**KIRKLEES METROPOLITAN COUNCIL
INVESTMENT & REGENERATION SERVICE**

DELEGATED DECISION TO DETERMINE PLANNING APPLICATIONS

Reference No:	2025/62/91043/W
Site Address:	33, Leyfield Bank, Wooldale, Holmfirth, HD9 1XU
Description:	Removal of existing garage and erection of single storey rear extension with associated alterations
Recommending Officer:	Joshua Merriman

HOUSEHOLDER DELEGATED REPORT

scale	date	sheet size	dwg. no.
1:100	02/2025	A2	25/1139/04d

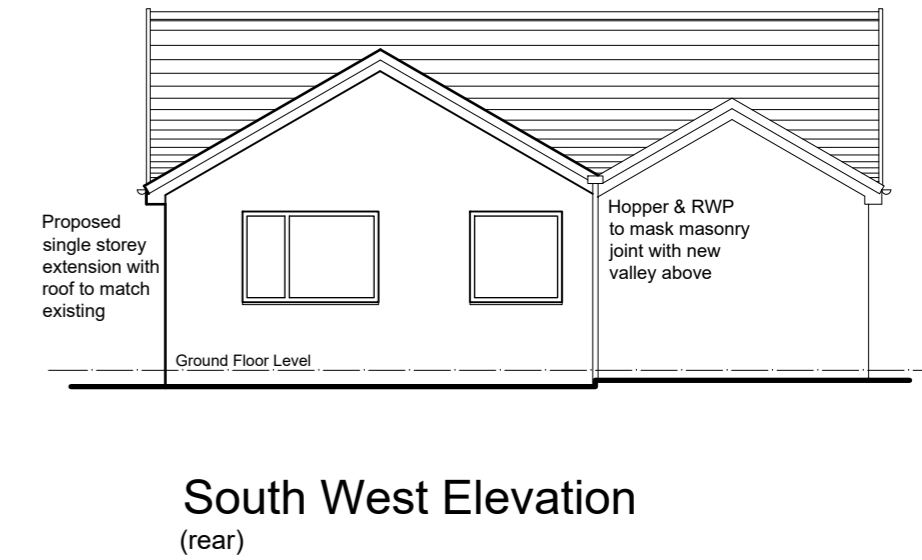
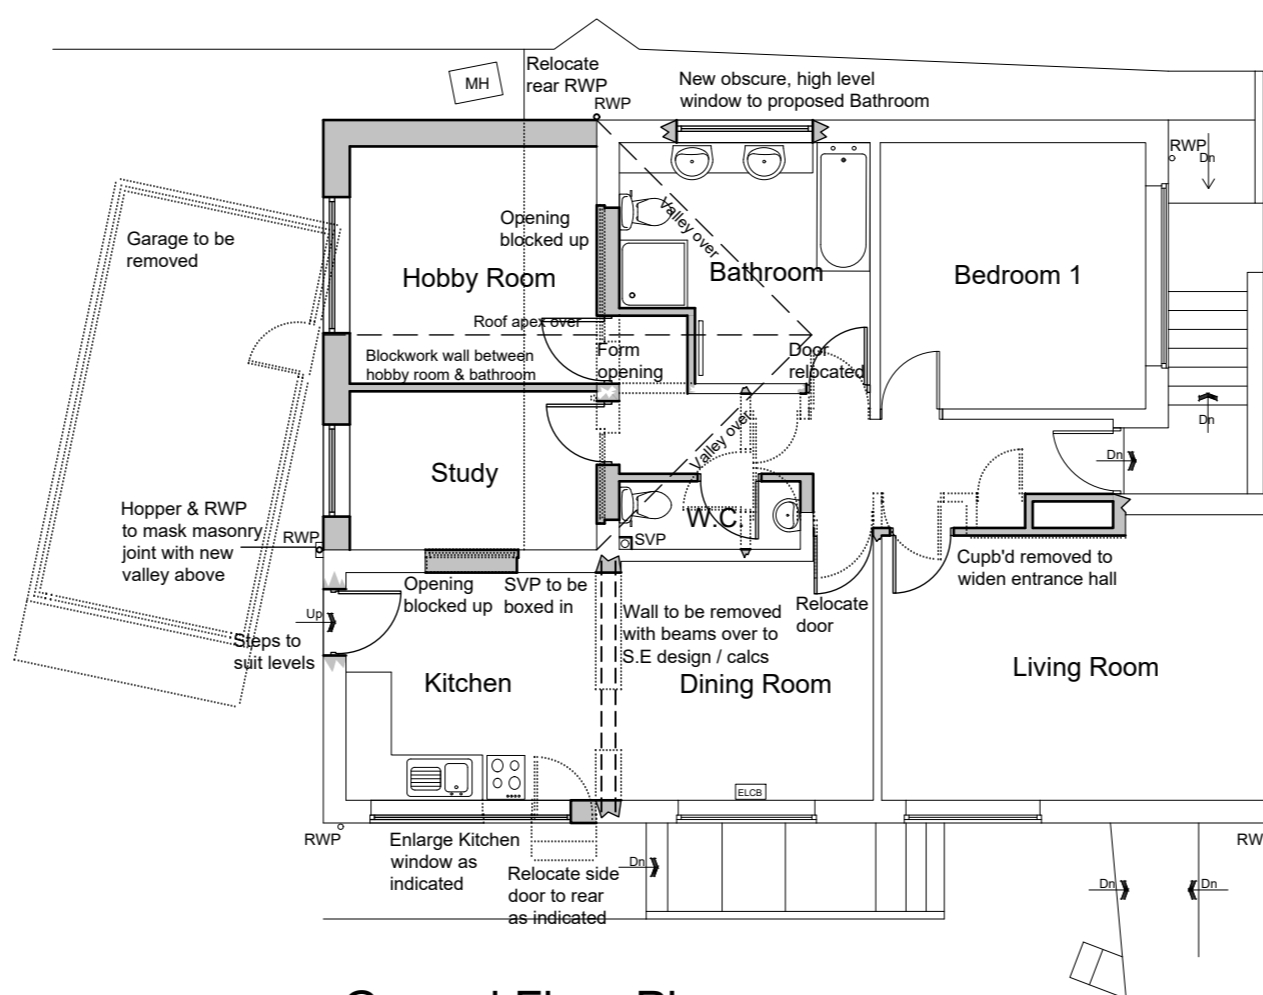
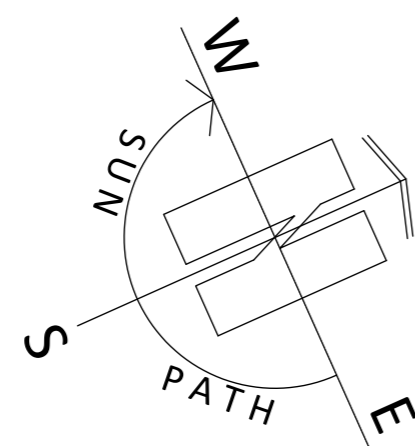
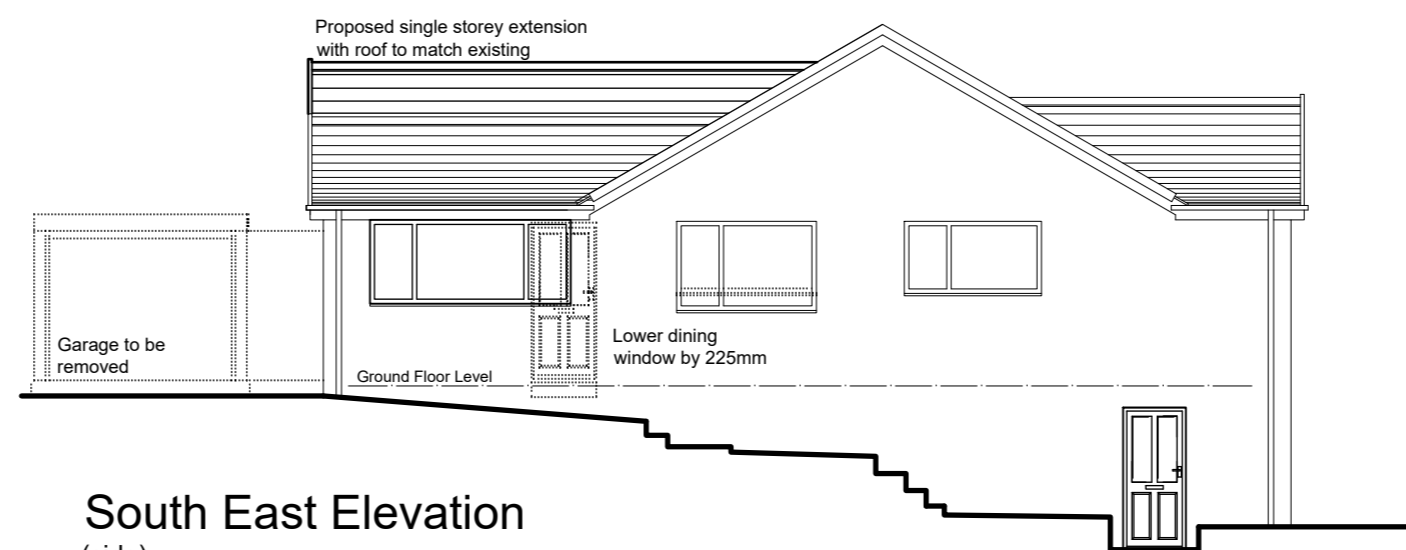
Negotiations/Amendments during course of application	Yes	The applicant submitted amended plans during the application process including a high-level obscured bathroom window to the rear elevation, which is considered to be acceptable.
Parish/Town Council comments sought	Yes	Holme Valley Parish Council have been consulted regarding the application, but have offered no comments.
Planning History	No	
Consultations required	No

The proposed single storey rear extension will align with the rear elevation of the existing building, with a maximum height of 4.38m, eaves height of 2.29m, and a width of 3.63m.

not exceed 4 metres in height		The maximum height of the extension is 4.38m, exceeding 4m, however, the height of the extension is to

Facing materials and detailing	<ul style="list-style-type: none"> • KDP 9 of the SPD 	The proposal is to be faced in brickwork walls, with uPVC windows and doors, all of which match	✓

<ul style="list-style-type: none"> • Policy LP24 Design (d) (iii) of the KLP • Chapter 12 of the NPPF 	the existing dwelling. Although a composite door is also proposed, this is not highly visible due to its position to the rear of the house and is therefore acceptable.	
Roof style	<ul style="list-style-type: none"> • KDP 1 and 2 of the SPD • Policy LP24 Design (a), (c) and (d) of the KLP • Chapter 12 of the NPPF 	The roof is to be pitched concrete tiled to match that of the existing building.	✓
Window proportions	<ul style="list-style-type: none"> • KDP 1 and 2 of the SPD • Policy LP24 Design (a), (c) and (d) of the KLP • Chapter 12 of the NPPF 	All windows proposed in the extension are proportionate to those existing with regard to size and positioning.	✓
Accessibility for all users	<ul style="list-style-type: none"> • KDP 17 of the SPD • Policy LP24 Design (f) • Chapter 12 of the NPPF 	Private domestic extension – no alternate access arrangements required.	✓

match the existing building, and this is considered more favourable with regard to visual amenity, therefore, it can be considered acceptable in this case.
not project out more than 3 metres from the rear wall of the original house for semidetached and terraces houses or by 4 metres for detached properties	The extension will not project any distance beyond the rear elevation of the existing dwelling.	
where they exceed 3m in length the eaves height should generally not exceed 2.5 meters	The eaves height of the extension is 2.29m, not exceeding 2.5m.	
retain a gap of at least 1 metre from a property boundary, such as a wall, fence or hedge		A gap of only 0.92m is maintained to the North West property boundary, however, this is not considered to have any significant impact upon neighbouring dwellings and can be accepted in this case.

application advice service available, complied with the Kirklees Development Management Charter 2024 and otherwise actively engaged with the applicant in dealing with the application. The applicant submitted amended plans during the application including a new obscure high-level window in the rear elevation of the bathroom, which was considered acceptable.
